## NSW RURAL FIRE SERVICE

Our reference: D19/2934

### Notification of Modification Application for Teralba Recycling Facility

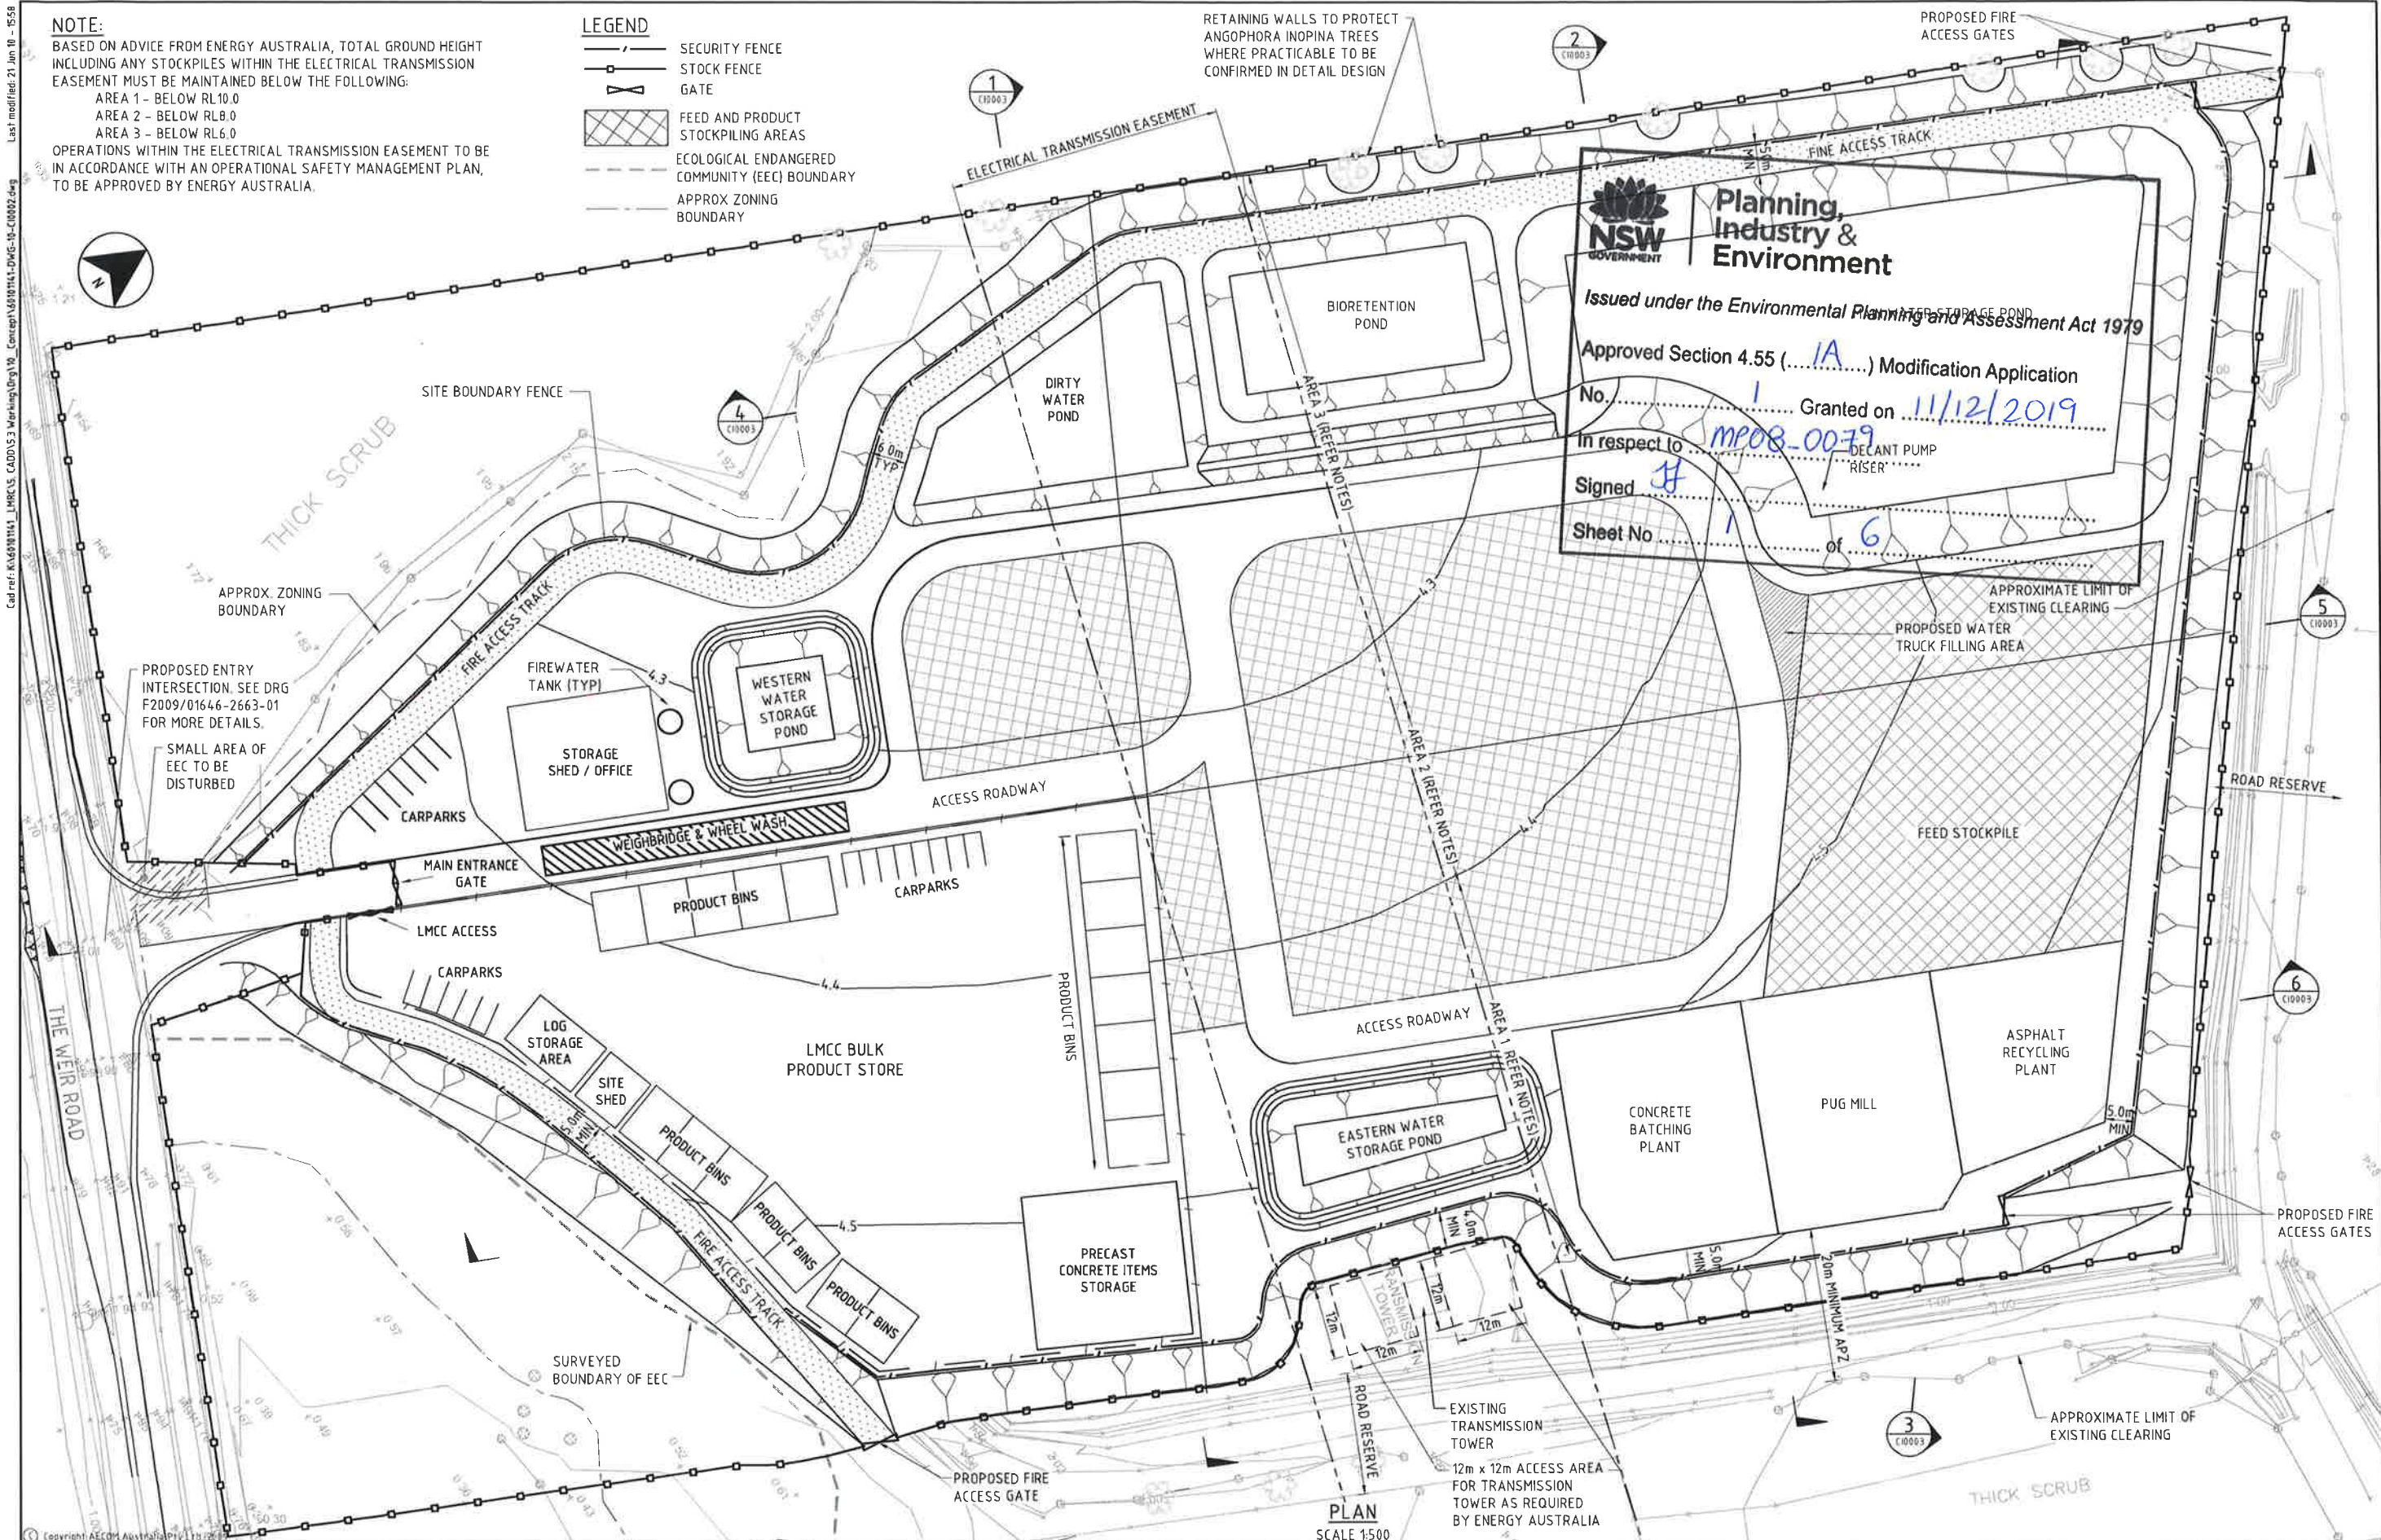
The New South Wales Rural Fire Service (NSW RFS) has reviewed the information provided and advises that no objections are raised to the proposed modifications subject to compliance with the requirements of the NSW RFS correspondence dated 30 September 2010. It should be noted that 20 metre asset protection zones (APZs) are required to be maintained around the proposed buildings for the life of the development. These APZs are not shown on the submitted modified site plan.
